**Laurie Leader - Re: BP#2014-023767 Newbury Street - Plan review questions**

I am handling the plan review for 73 Newbury Street. Can you please clarify the following:

3
A8
RESTORED NORTH ELEVATION
SCALE: 1/4" = 1'-0"

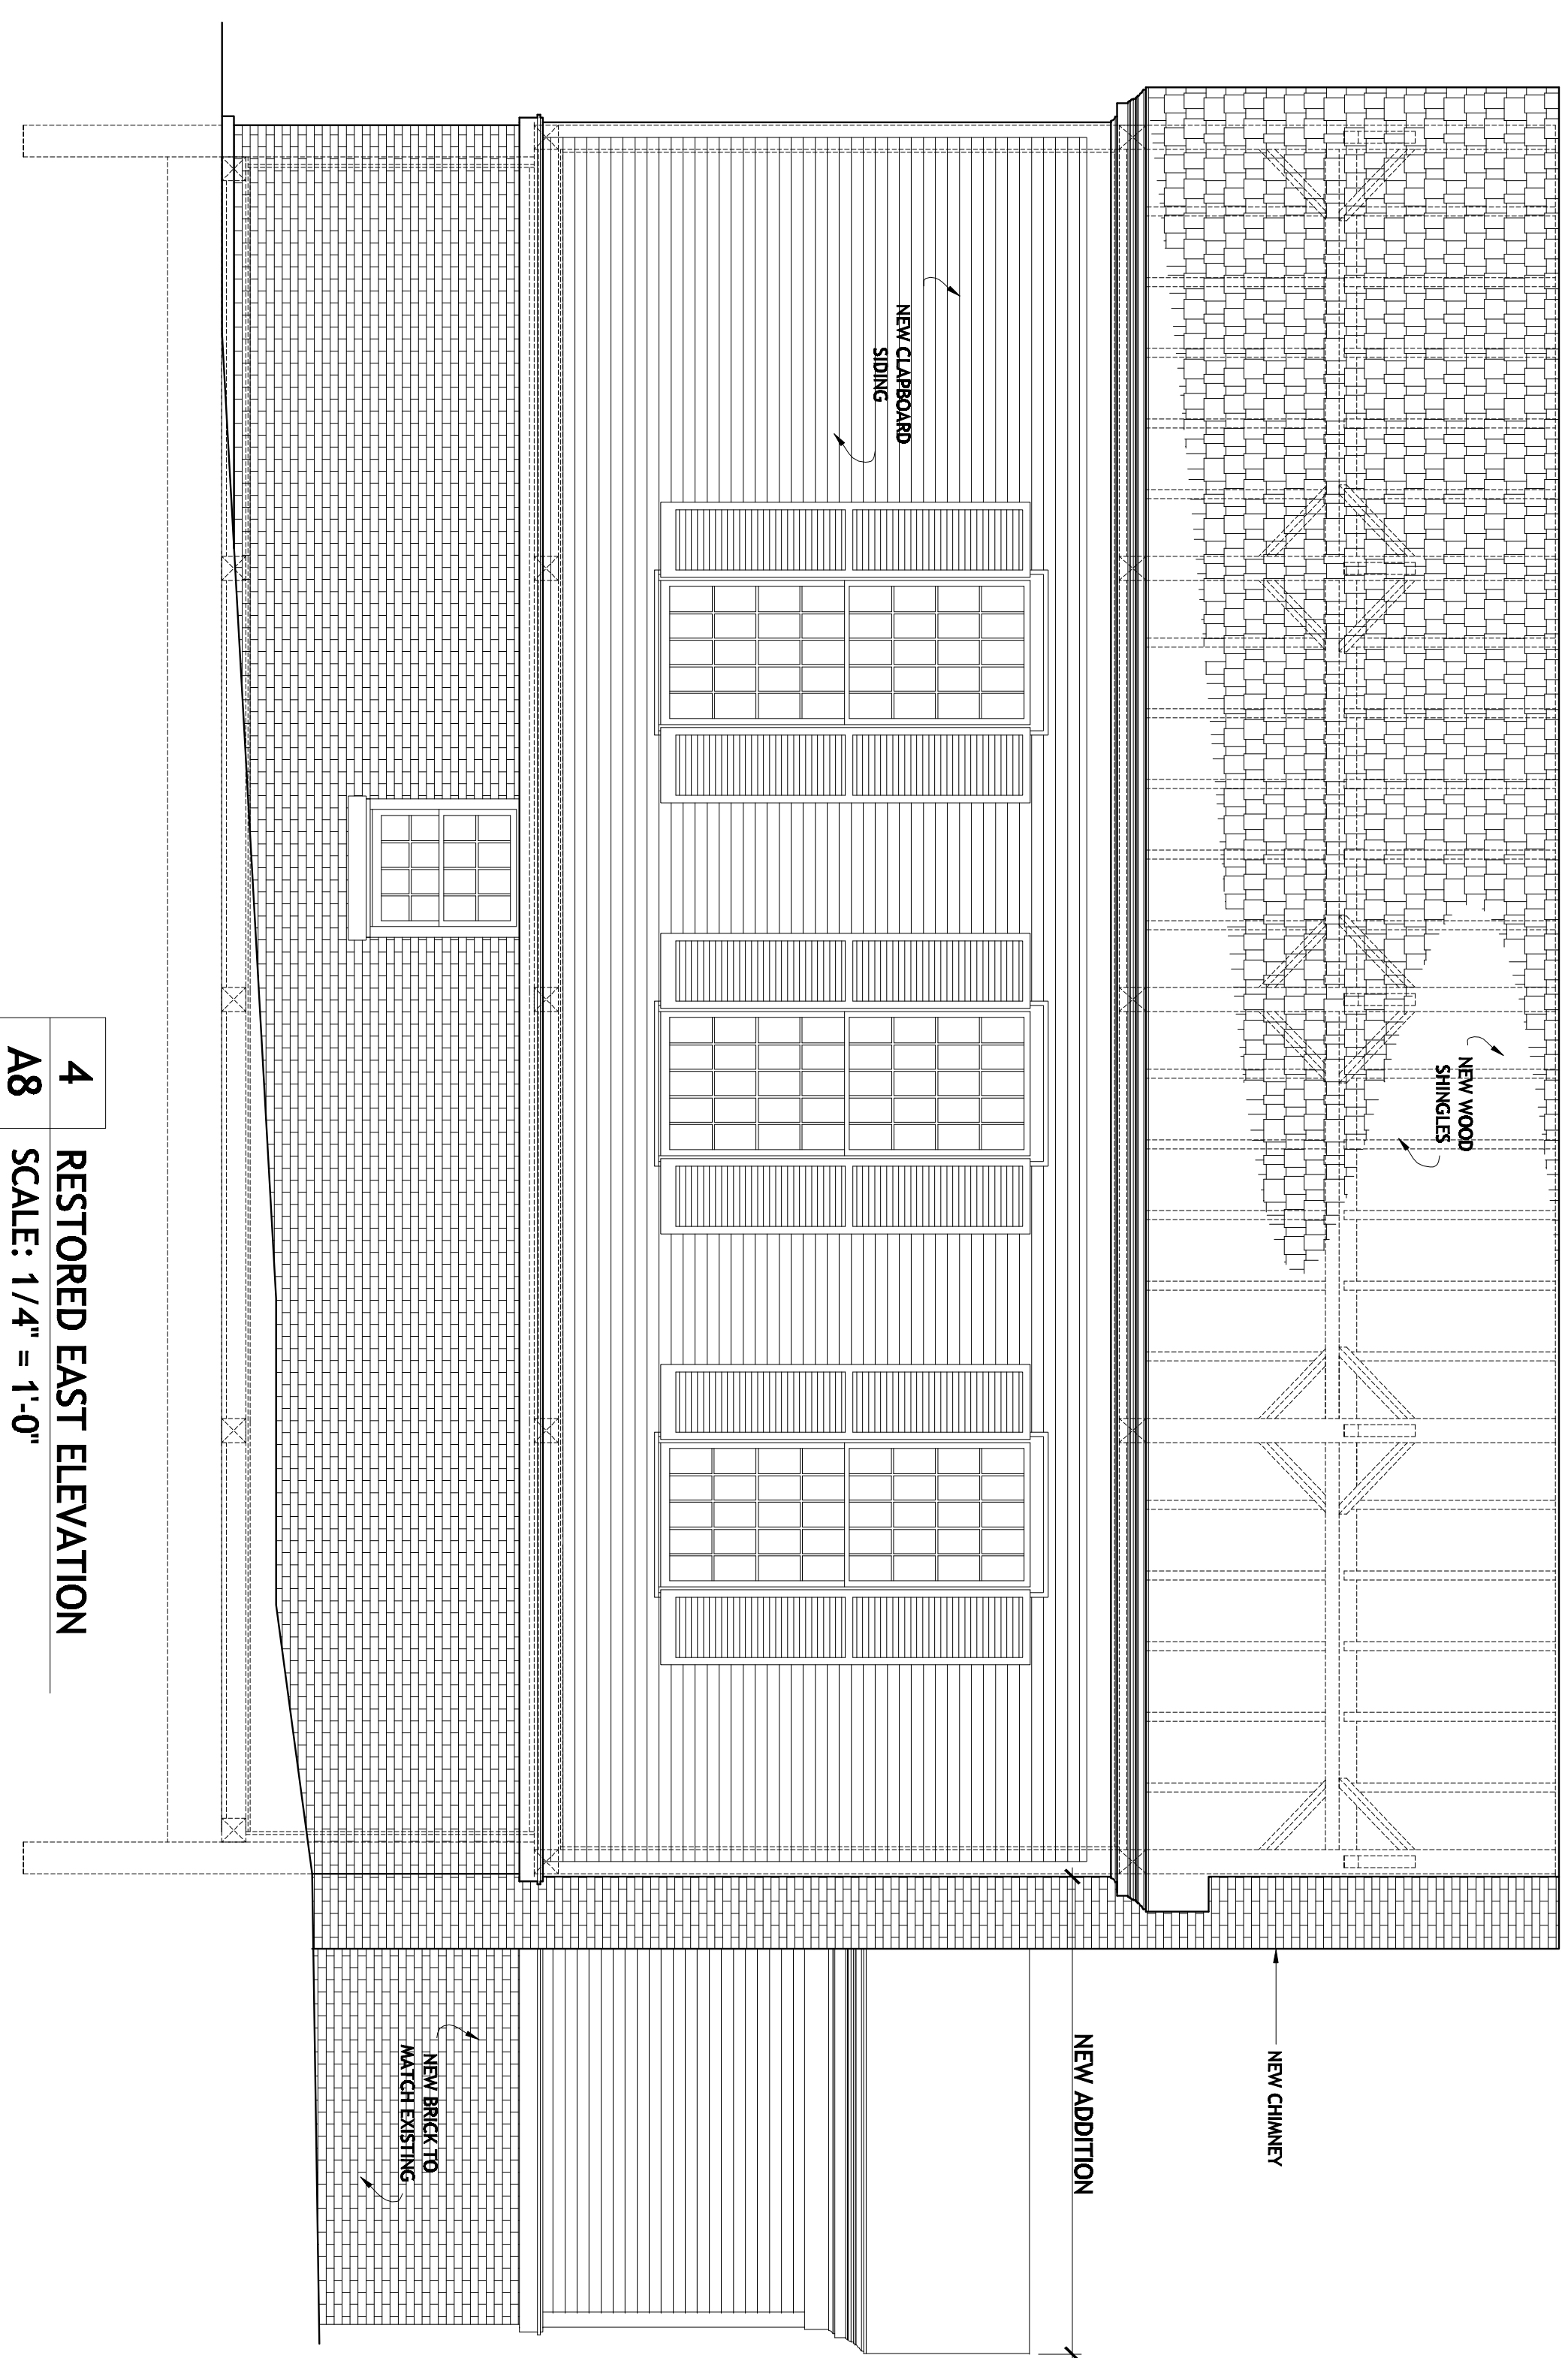
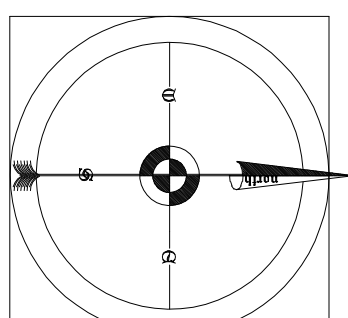
1. Is the use of the building going to be a museum/meeting house or a church/community center?
2. Are windows being installed in the rough openings?
3. Can you clarify what the interior demolition consists of? The plans do not reflect any interior demolition.
4. Can you provide dimensions on the plans for the proposed rough openings?

The rough opening for the windows is 4'x8', this is based on the evidence found during our previous demolition and to match that of the windows in the front gable.
